Nottinghamshire County Council

Local Impact Report – Steeple Renewable Project

Steeple Renewables Project
Figure 1: Proposed Trench Plan and Geophysical Survey Interpretation Data

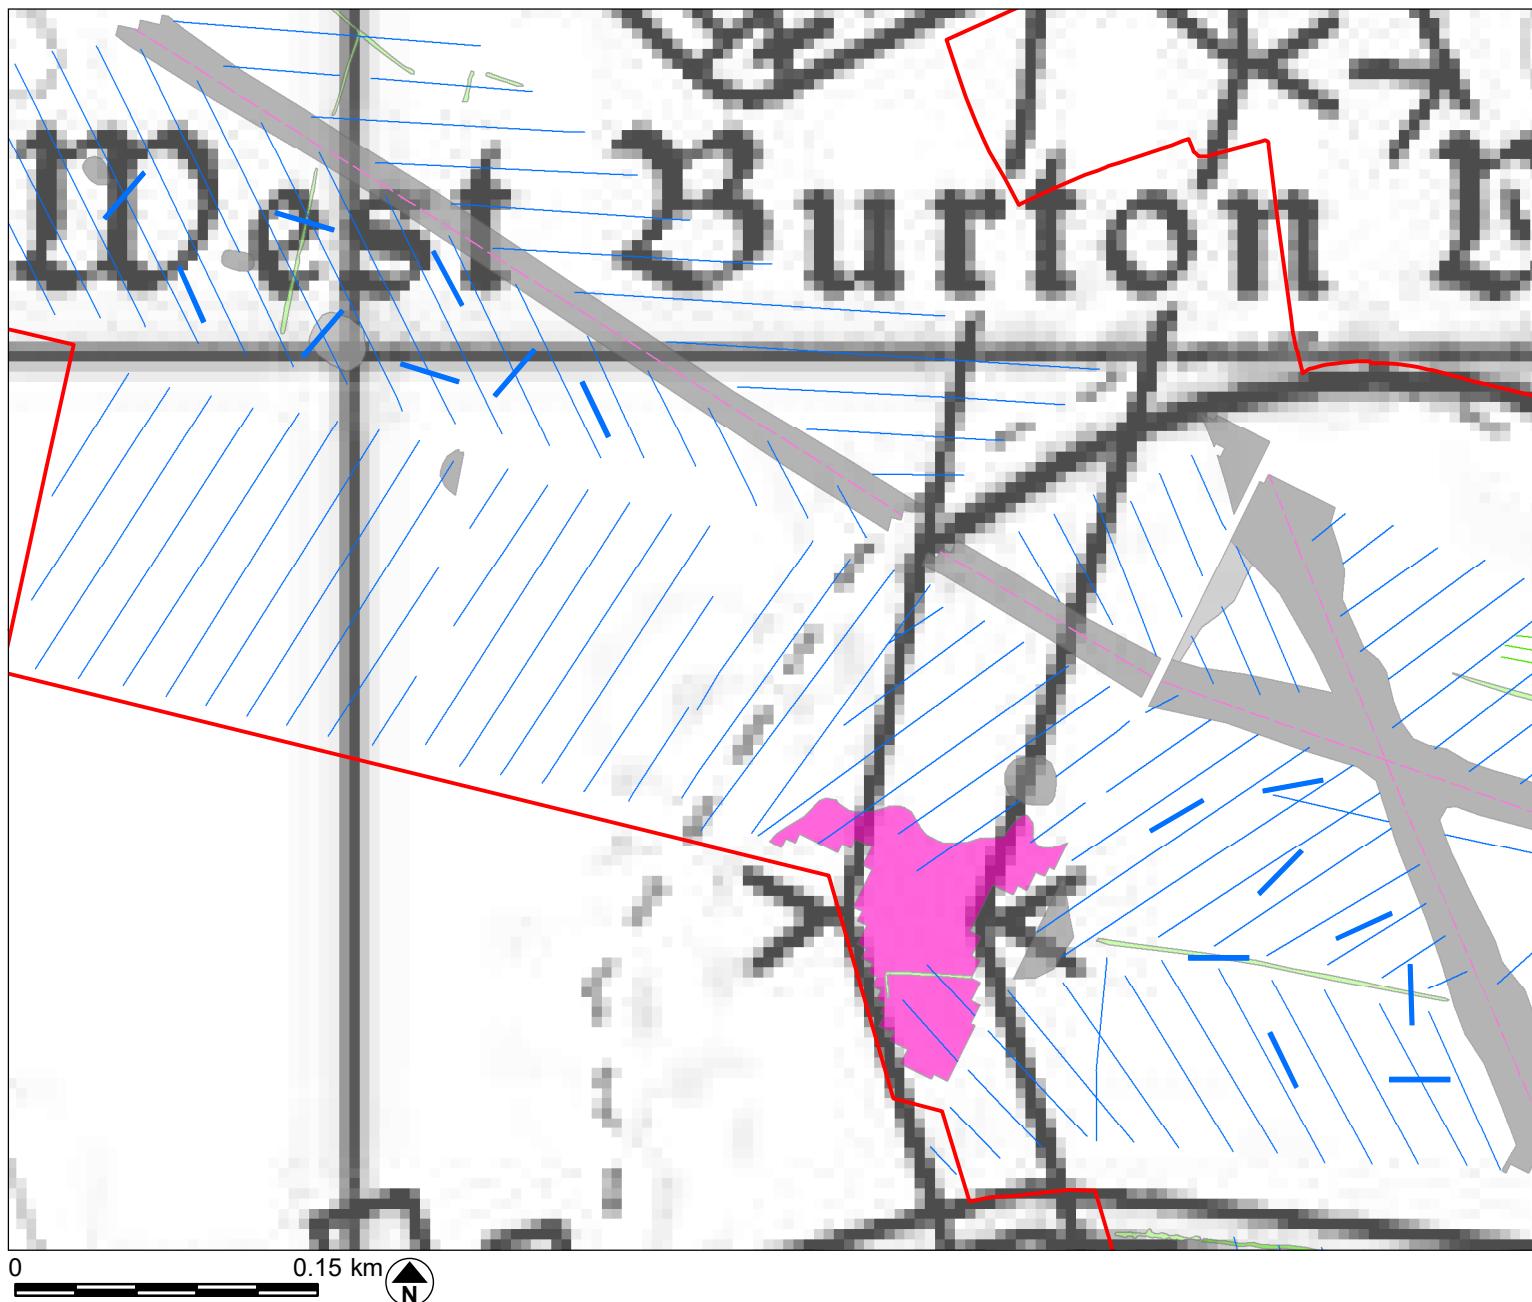
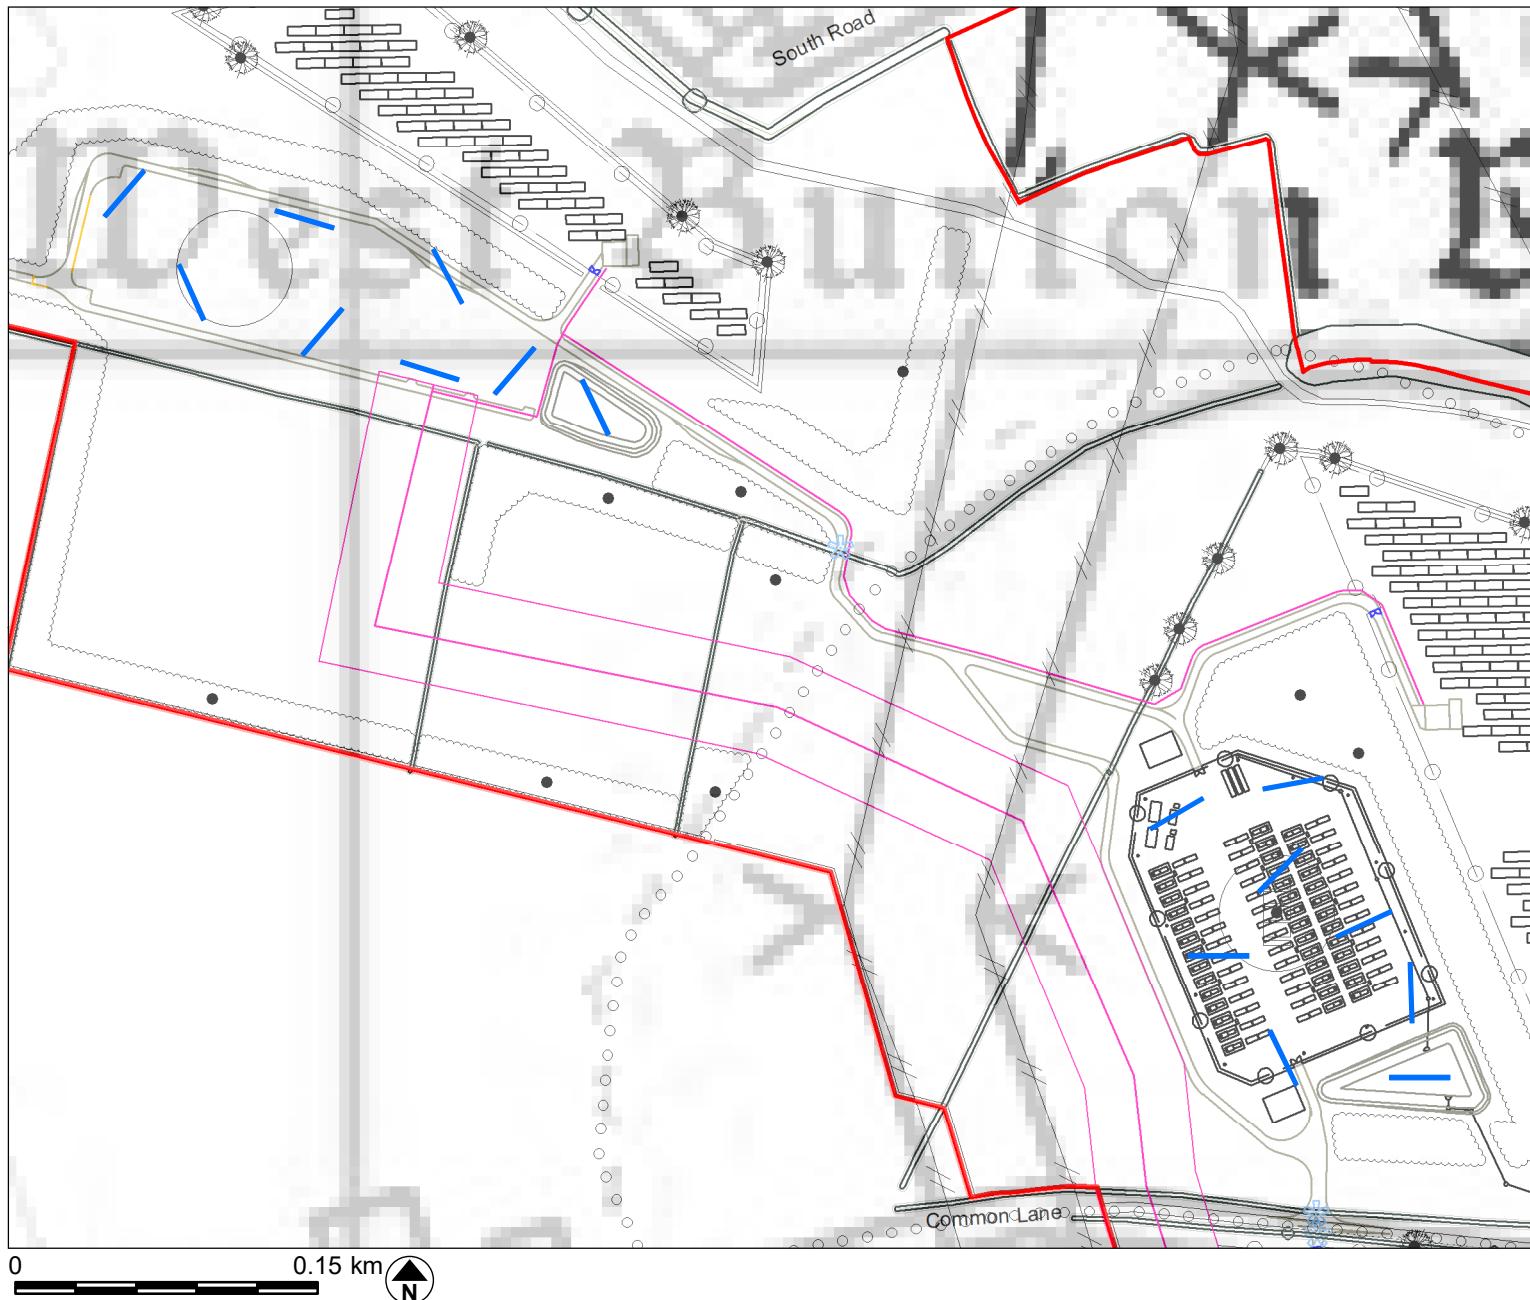
- 5.2.8. **The applicant has recently undertaken limited trial trench evaluation of the BESS and substation compounds comprising 16 trenches. While this is welcomed, the overwhelming majority of the site remains un-evaluated and in a state where the applicant does not understand the archaeological resource sufficiently to assess the proposed development impact.**

- 5.2.9. The pre-determination trenching is confined to the BESS and substation area and does not include other areas of infrastructure such as new roads/tracks, cable trenching for both for connecting rows of panel arrays and for grid connection, or for landscaping and ecological management areas. It also fails to include the areas of archaeological sensitivity that their own assessment work has identified.
